### **Application by AQUIND Limited for an Order granting Development Consent for the AQUIND Interconnector Project**

#### **Agenda for Issue Specific Hearing 3 dealing with Environmental Matters (ISH3)**

<b>Title of meeting</b>	AQUIND Interconnector Issue Specific Hearing on Environmental Matters
<b>Date</b>	15 December 2020
<b>Time</b>	10.00 am
<b>Venue</b>	Online via Microsoft Teams invitation
<b>Attendees</b>	Invitees

DRAWING NO: EN020022-ES-24.2-Sheet3	REV.NO. 01
---	---------------

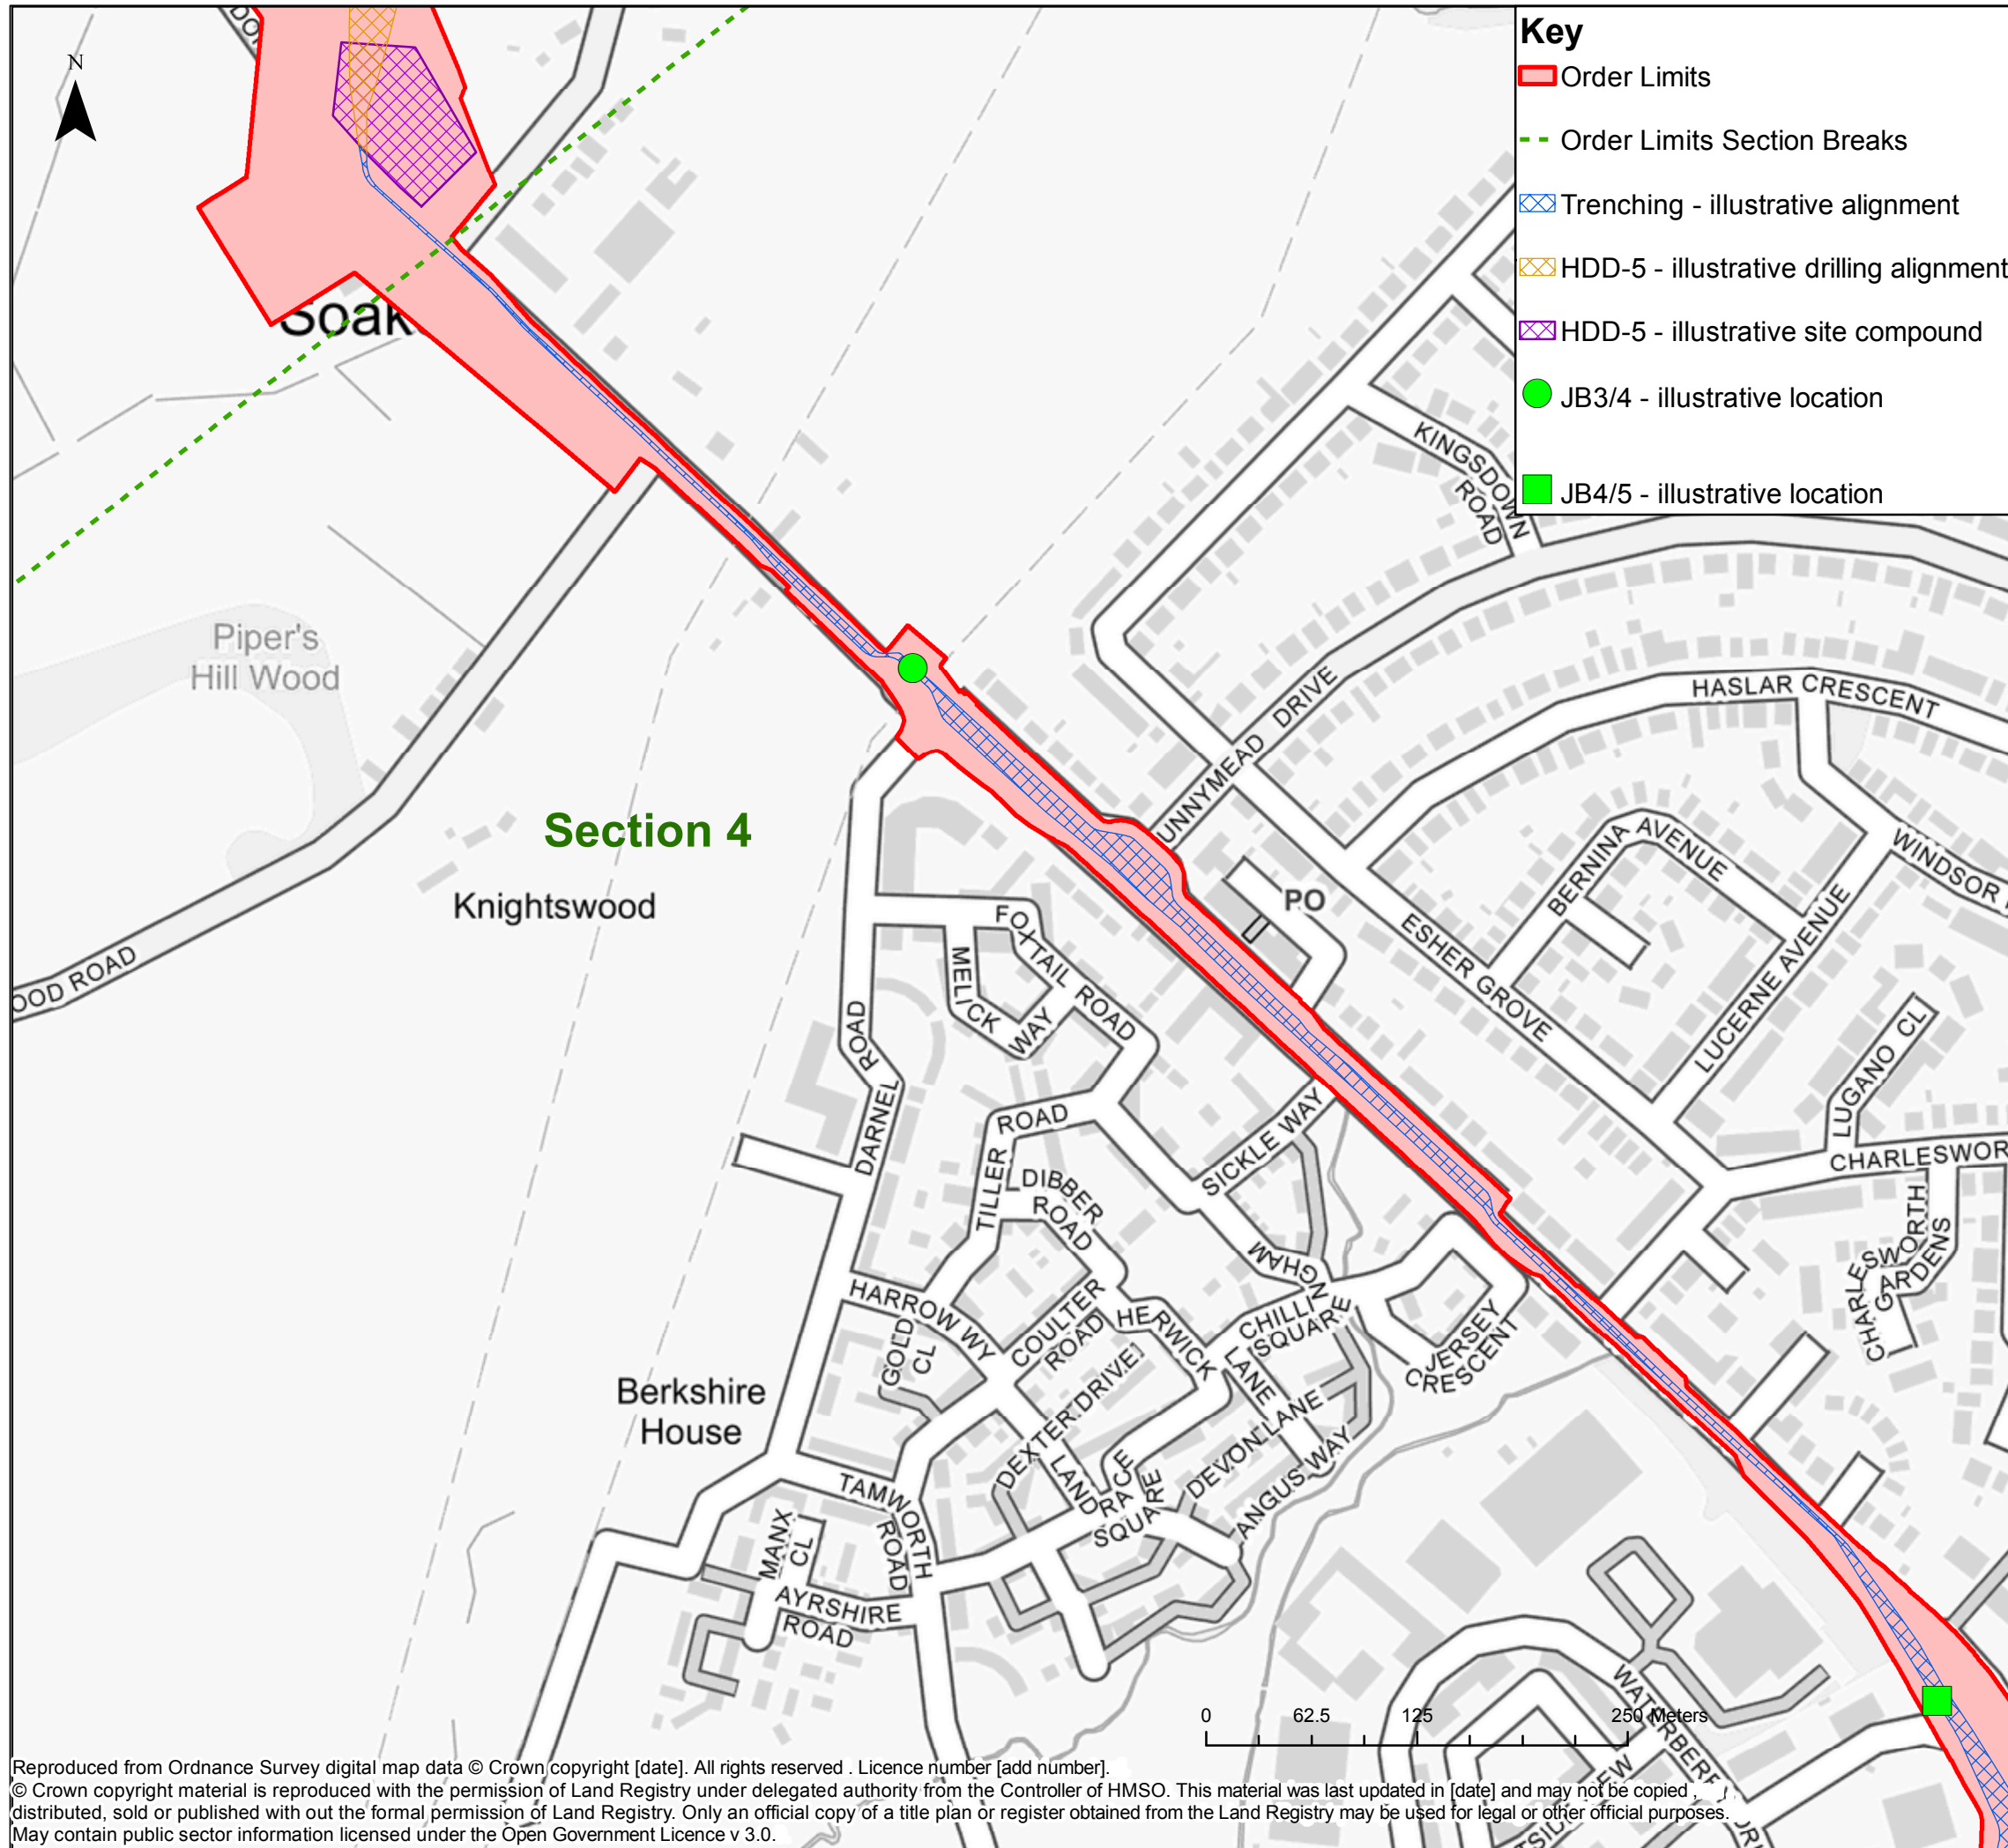
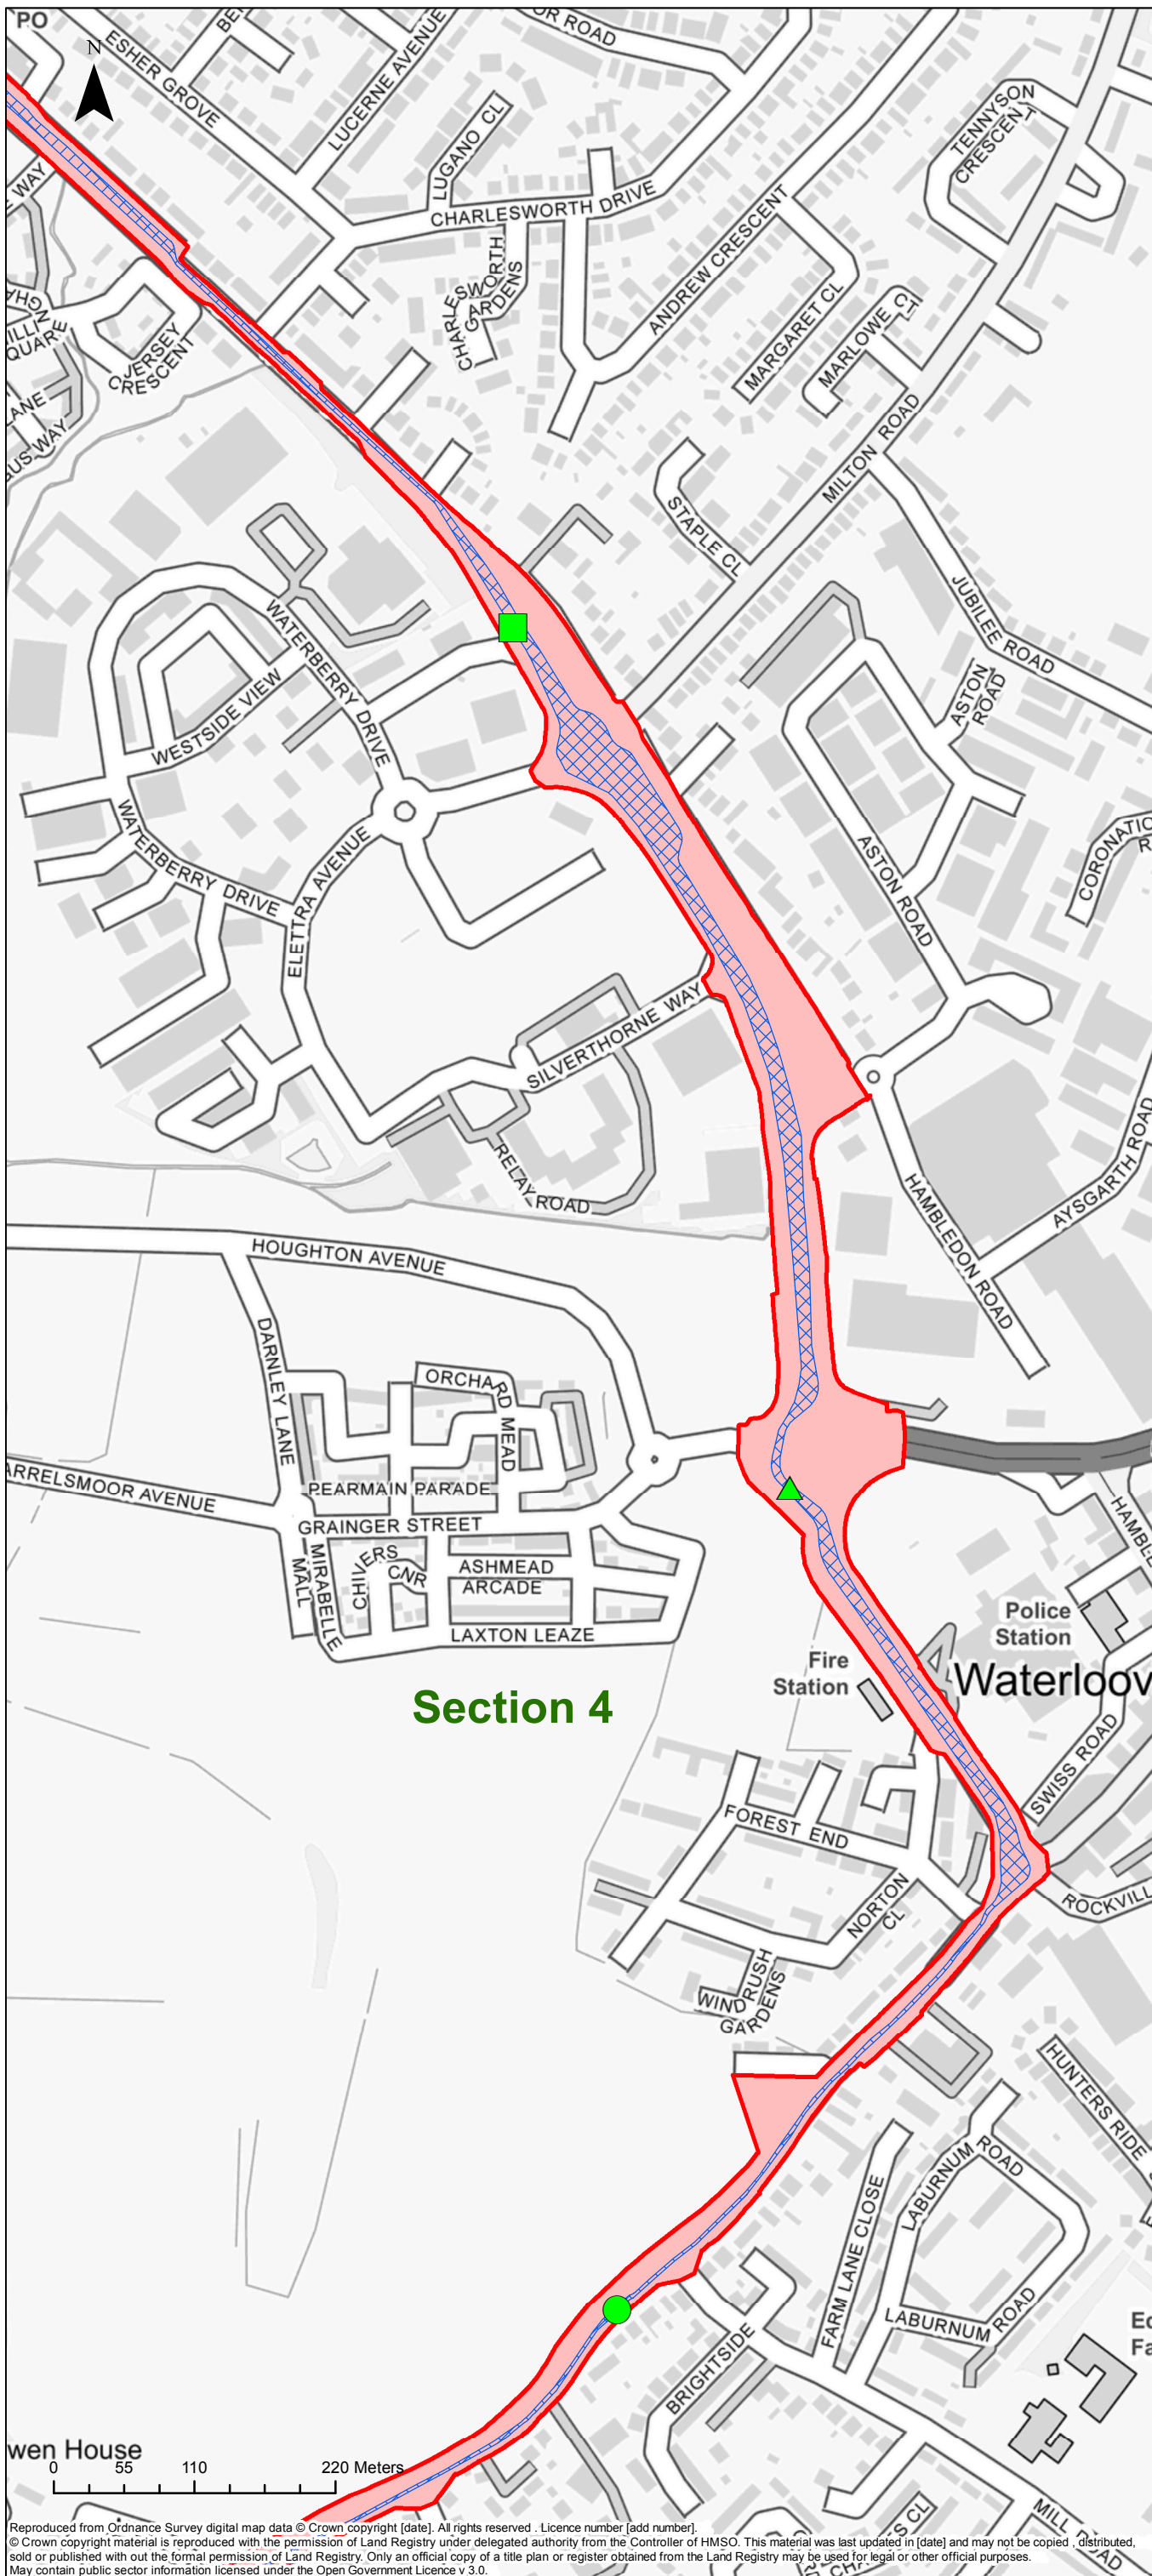
- With reference to ExQ1 N1.11.3, could the Applicant clarify the meaning of its response: *'Within the onshore cable corridor, the relative distance between the illustrative cable route and the noise sensitive receptors influences the magnitude of noise level experienced by any receptor. The magnitude of impact and overall noise effect assigned to this magnitude of level is influenced by the duration, timing and frequency of exposure to that noise level, which is not altered by the alignment of the cable route.'* The first part suggests that the distance between the cable installation and a receptor does influence the impact perceived at the receptor, as might intuitively be expected as noise diminishes with distance from source. The second part could be taken to contradict this. Notwithstanding the ultimate judgement of whether such an impact is significant or not, could ExQ1 N1.11.3 be reconsidered in respect of the different effects that might be perceived at sensitive receptors near those stretches of the route where it would be possible for installation to come substantially closer than the illustrative route?

- How robust is the assessment of magnitude of change in the noise environment and the determination of significance in the light of this? How does it relate to the adopted EIA approach of assessing the worst case?
